Our reference: DCO/2018/00015  
Your reference EN010092

**APPLICATION BY THURROCK POWER LTD FOR AN ORDER GRANTING  
DEVELOPMENT CONSENT FOR THE THURROCK FLEXIBLE GENERATION  
PLANT**

**MMO Deadline D Response**

**Thurrock Flexible Generation Plant
 Deemed marine licence coordinates plan**

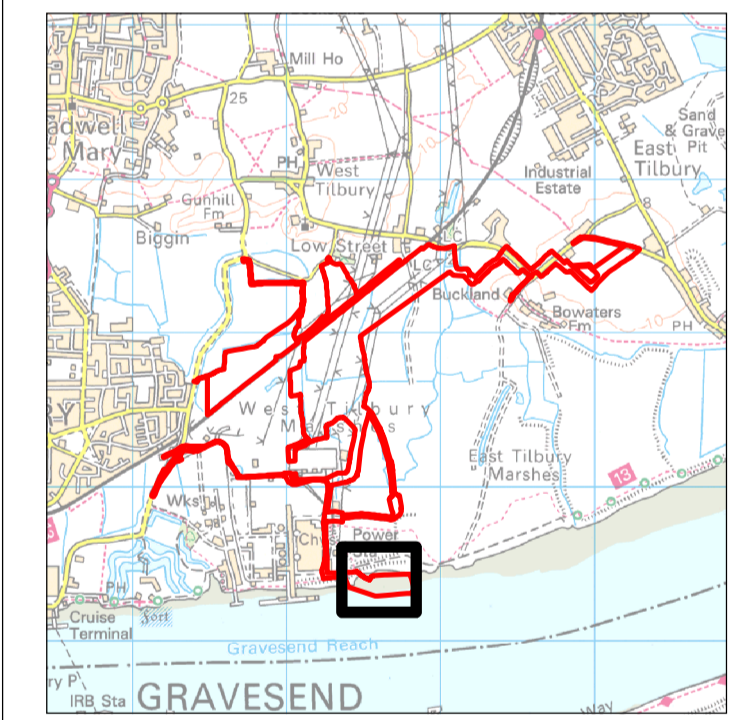
4.1. There appears to be a typographic error with 'licence' being spelt incorrectly. MMO advise this should be amended.

4.2. The MMO wish to highlight that it is the responsibility of the applicant to ensure that the area covered by coordinates are adequate for all activities in the marine environment, such as maintenance dredging etc.
